MIAG and Mcl PC written submissions from oral presentation;

Traffic; Junction 24;

MIAG – Comments on re-designed Inworth Road Roundabout

01-03-2023

HE551497 - JAC - LDC - S3_J24 -DR- C -0101

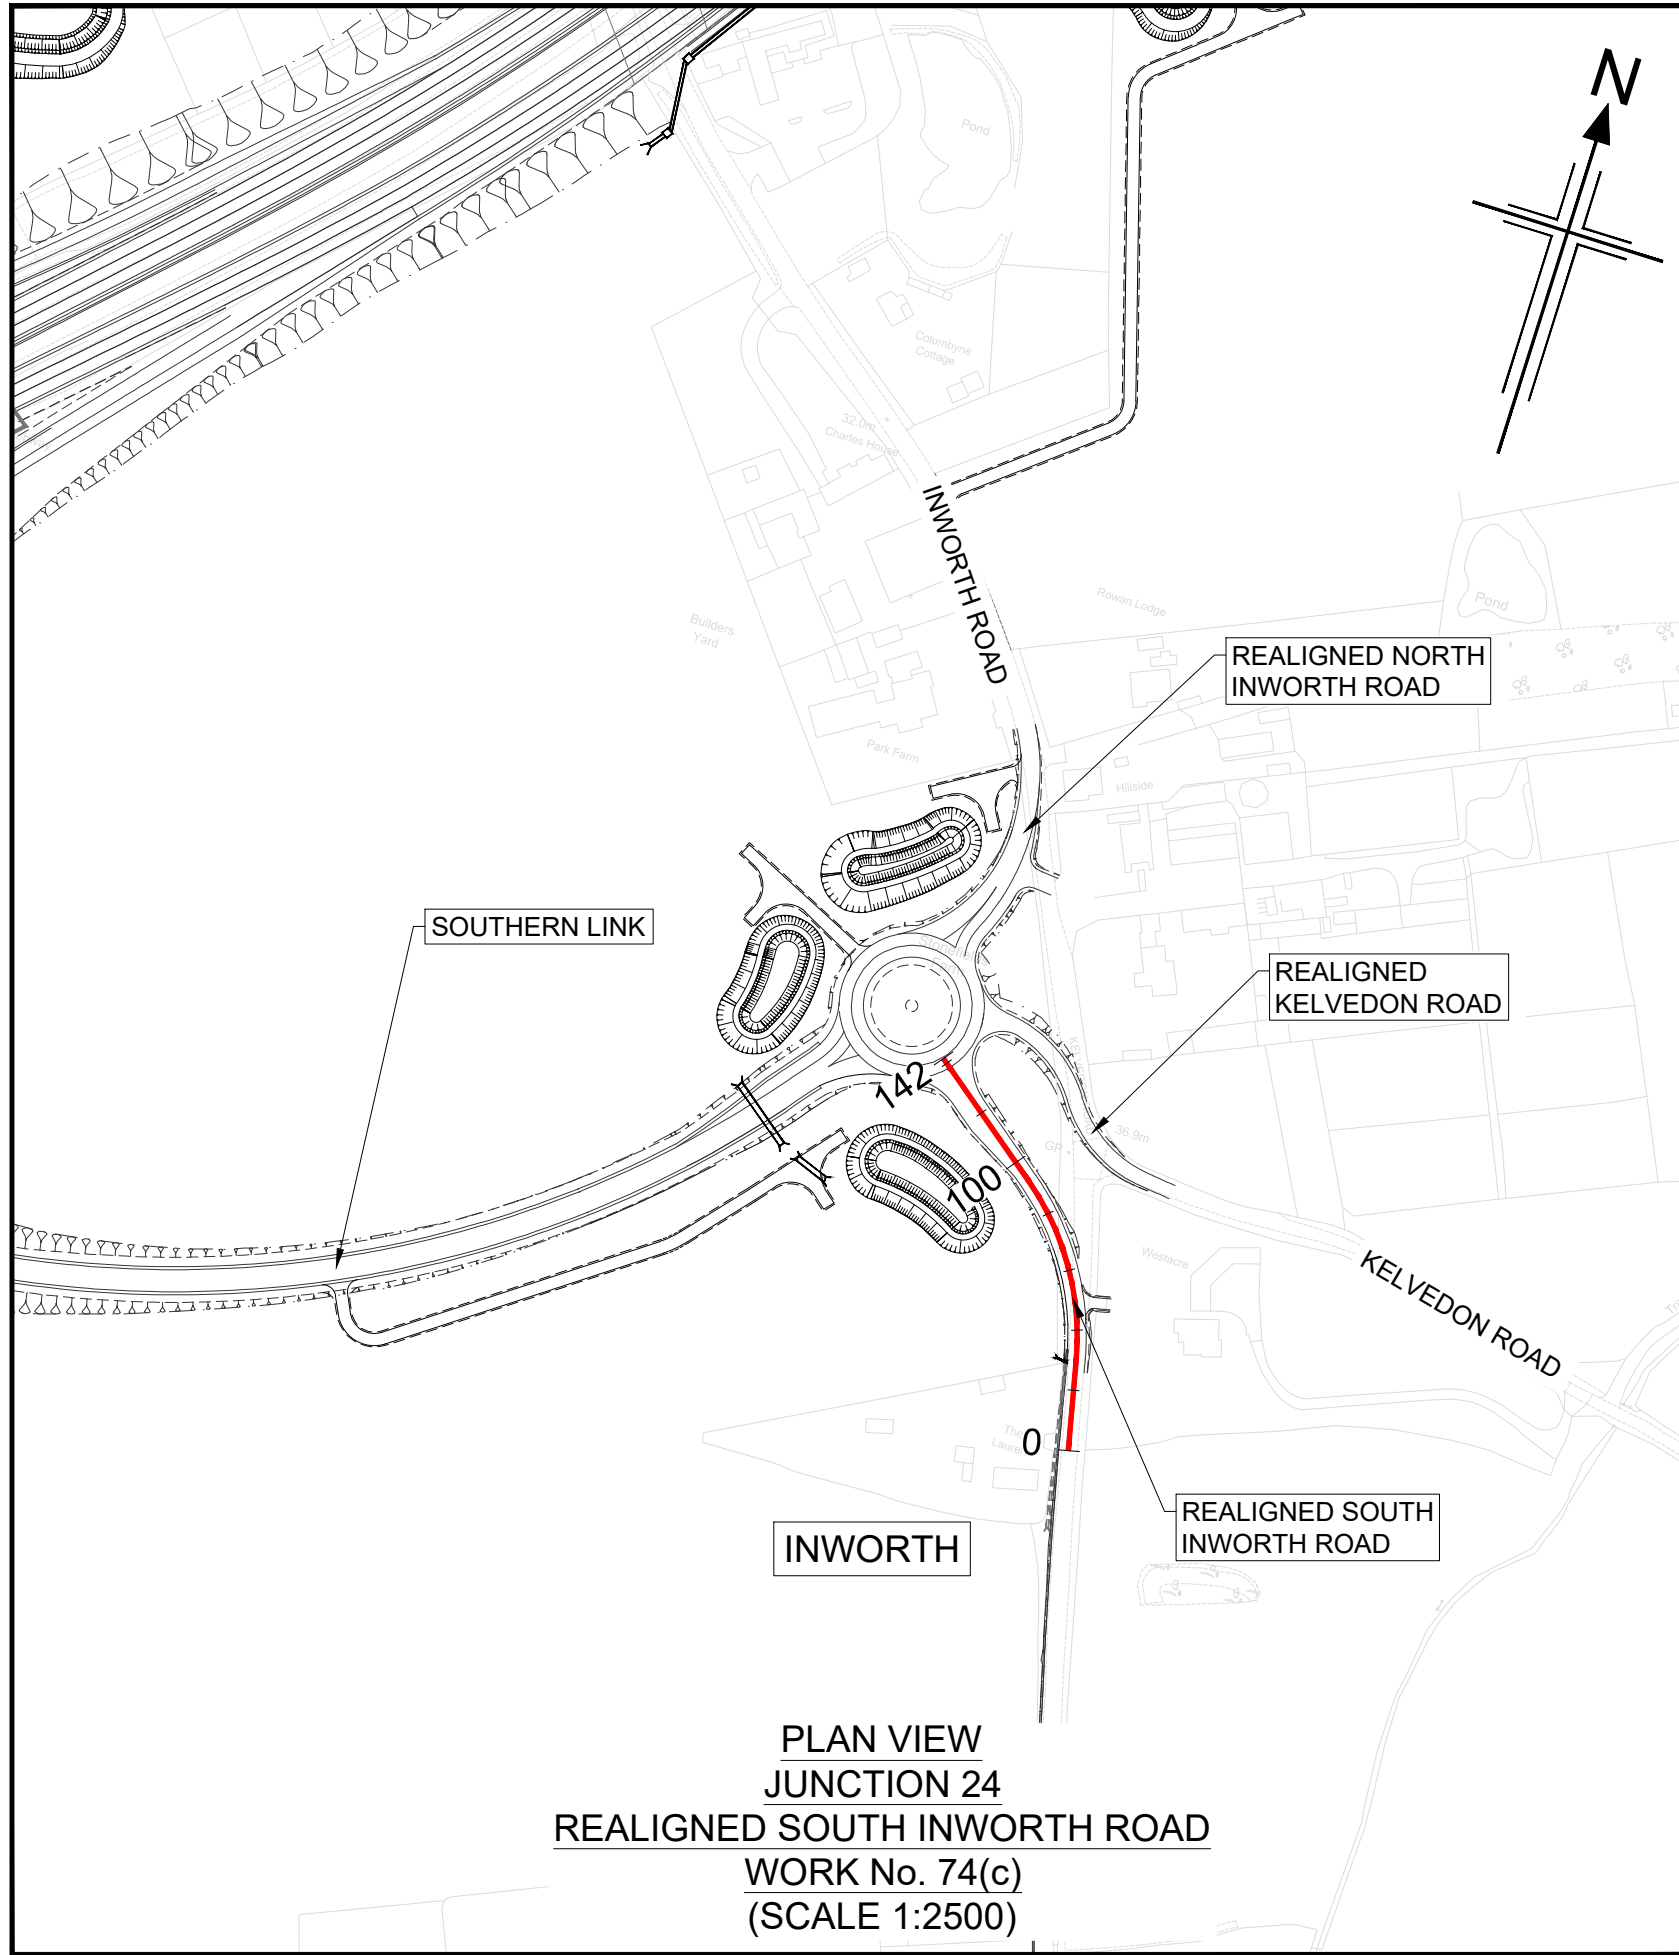
5. It is noted that the northern arm of the roundabout connecting to Inworth Road has an SSD that falls below 33m as a result of the existing wall surrounding Park Farm, which extends into the verge and would prevent visibility of the 'low object' of 0.26m height.

This re-design removes the largely redundant Segregated Left Turn Lane, which did not comply with Design Manual for Roads and Bridges standards in any case. There is also a variation in the geometry of the Inworth Road north approach arm. The centreline horizontal radius of 67.5 m has been increased to 75.0 m compared to the design submitted in the DCO application.

MIAG are concerned about the low values of SSD on the approach to and exit from the roundabout. The arm connecting to Inworth Road north of the roundabout is of particular concern and MIAG do not feel confident that even the value of 43m SSD has been achieved for this arm. In fact, the proposed back of verge and earthworks appear to encroach into the Park Farm boundary. SSD checks carried out by NH only continue to as far as the tie in of the new works with the existing Inworth Road. This does not show the full effect of the new works on SSD. If SSD checks are continued further along Inworth Road a 43m SSD line would be obscured by the existing brick wall on the boundary of Park Farm (Figure 1.). Over this length visibility values, at 5m intervals were measured, the results were as follows: 40.5m, 37.2m, 34.2m, 32.3m, 33.2m (Figure 2.). This would indicate a length of about 30m of the alignment where the claimed 43m SSD is not achieved. What makes this more worrying is that there is an entrance to Park Farm immediately following this reduction in available visibility. This would make access and egress extremely hazardous for residents of Park Farm when vehicles approaching after leaving the roundabout will have very little forward visibility.

The application of super-elevation does not appear to have been considered for any of the arms of Inworth Road Roundabout. For the arms that use low values of horizontal radius the values of super-elevation would need to be the maximum advised value of 7% for a rural road (or 5% for an urban street). Radii of 75 m for Inworth Road north arm, 90 m for Inworth Road south arm have been used. DMRB standards would require the maximum value of 7% super-elevation to be applied to radii of 75 m and 90 m for a rural road. Application or changes in super-elevation would normally be provided over the length of transition curves connecting straight or circular curved elements of a horizontal alignment. In this design no transition curves have been provided, therefore the advice of DMRB is to apply between half and two thirds of the super-elevation on the approach straight and the remainder on the circular arc.

No approach straight has been provided for Inworth Road north arm at the tie in to the existing road. The minimum length of application of super-elevation was calculated to be 30.4 m, this being the shortest length of application and assumes a linear change in gradient of the outer channel and the road centre line of a constant 1% (a reverse curve profile could be used but would double the length of application to 60.8 m). Ideally an approach straight of about 20m length would need to be added to the alignment so that two thirds of the super-elevation can be applied before the beginning of the circular arc. Figure 5, below, shows the extents of the 7% super-elevation that can be applied on the approach to the roundabout.

At the roundabout end of the alignment +7% super-elevation would need to be reduced to -2% before the roundabout give way line. As the carriageway is wider at this end of the alignment the length of application of super-elevation will increase. The length to apply a change from +7% super-elevation to -2% cross fall at the give way line was calculated to be 47 m. This change in superelevation would occur mostly where the centreline horizontal radius is 75m and would leave less than 20 m length of this curve with the required 7% super-elevation. This is always a problem when approach arms to a roundabout are not designed with straight or near straight horizontal alignments.

LONGITUDINAL SECTION
JUNCTION 24
REALIGNED KELVEDON ROAD
(SCALE H=1:2500, V=1:500)

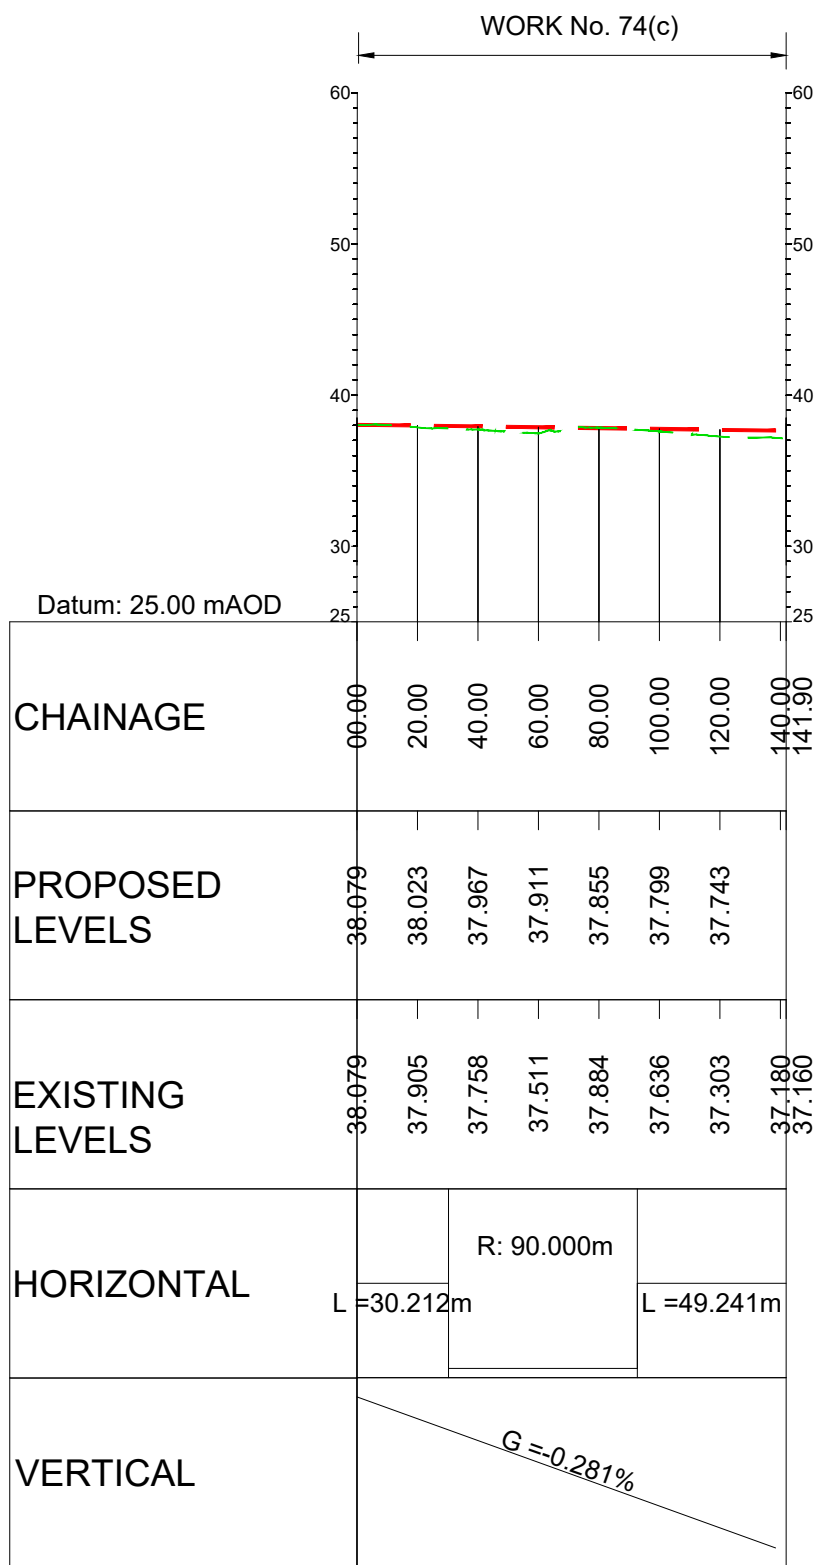
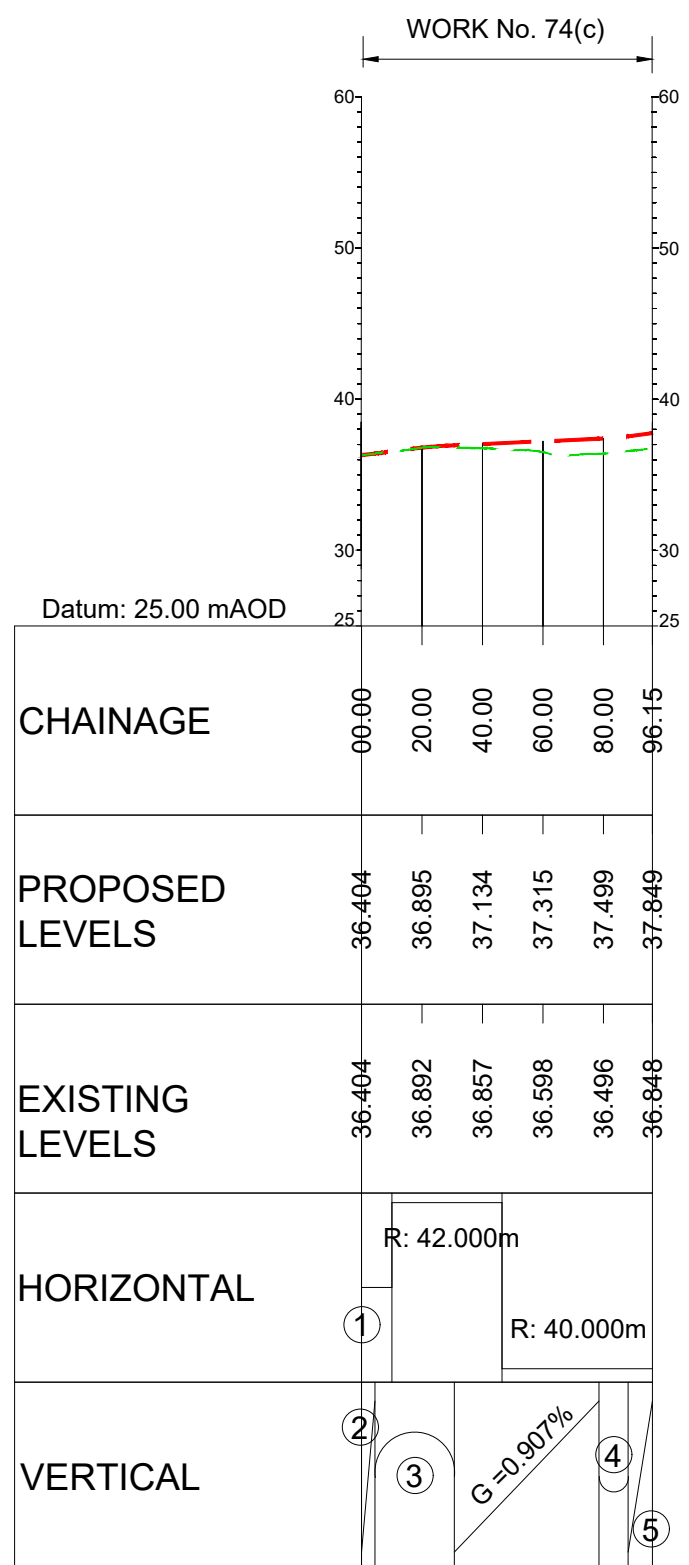
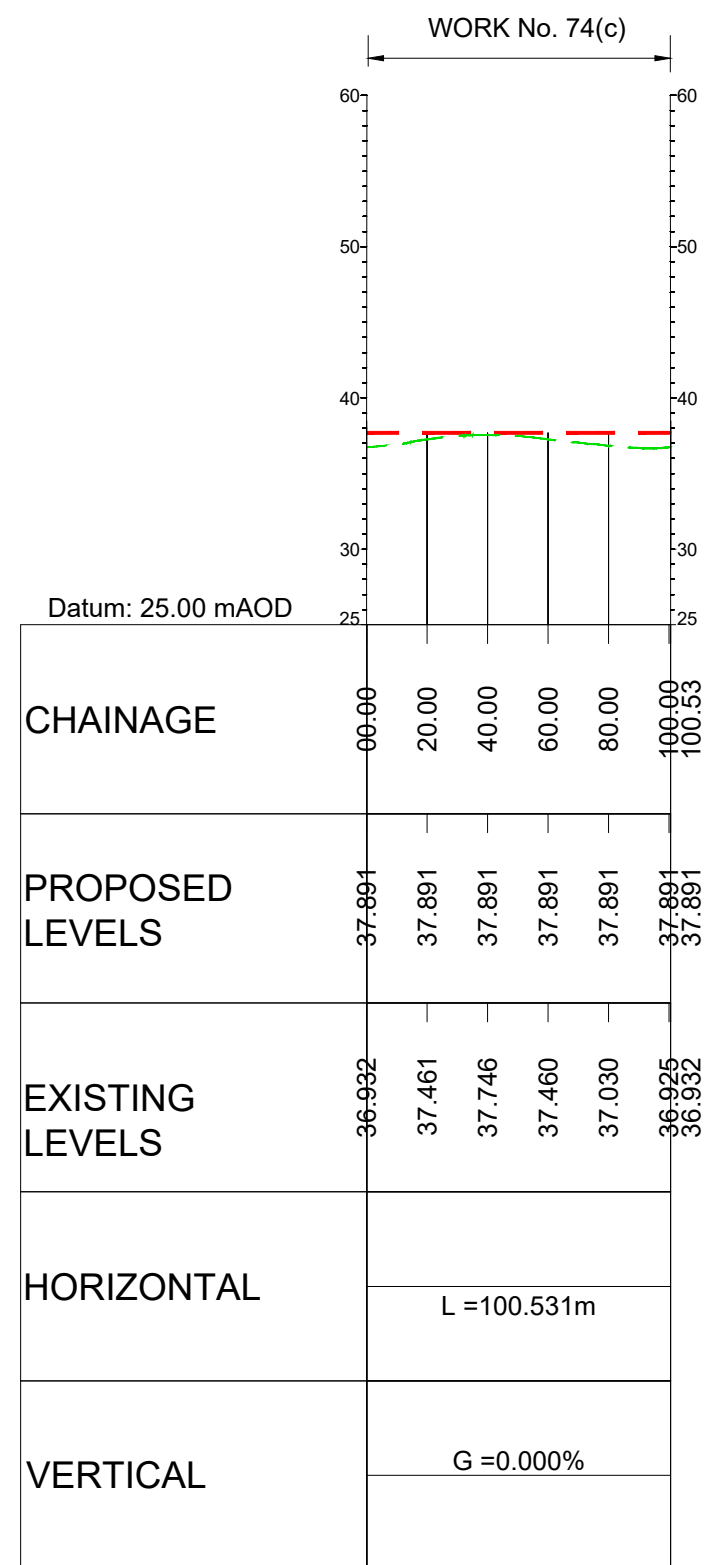
Exit visibility for Kelvedon Road, the eastern arm of the roundabout, does not seem to have been considered. In this case values of SSD would fall to as low as 26 m, with the 43 m long visibility line crossing the DCO boundary into the adjacent property (Figure 3.).

Kelvedon Road would also present problems with application of super-elevation, since its horizontal alignment comprises of back-to-back curves of opposite hand with no transition curves between them. In this case reduced values of super-elevation could most likely be justified, as vehicle speeds would be slower than along Inworth Road and with lower traffic volumes.

Widening for the swept path of heavy goods vehicles has not been provided for the Kelvedon Road arm of the roundabout. By providing widening the geometry of the entry kerb radius for Kelvedon Road and the exit kerb radius for Inworth Road south would need to be amended (Figure 6.). Currently the channel line from Kelvedon Road to Inworth Road is not tangential with the roundabout Inscribed Circle Diameter (ICD). Retaining the same values for entry and exit kerb radii would push the channel line even further away from the roundabout ICD if Kelvedon Road was widened to cater for HGV swept paths. Either smaller values of entry and exit kerb radii would have to be used, although this would not be ideal since the entry kerb radius is currently at the minimum required value, or Inworth Road south arm would need to be realigned.
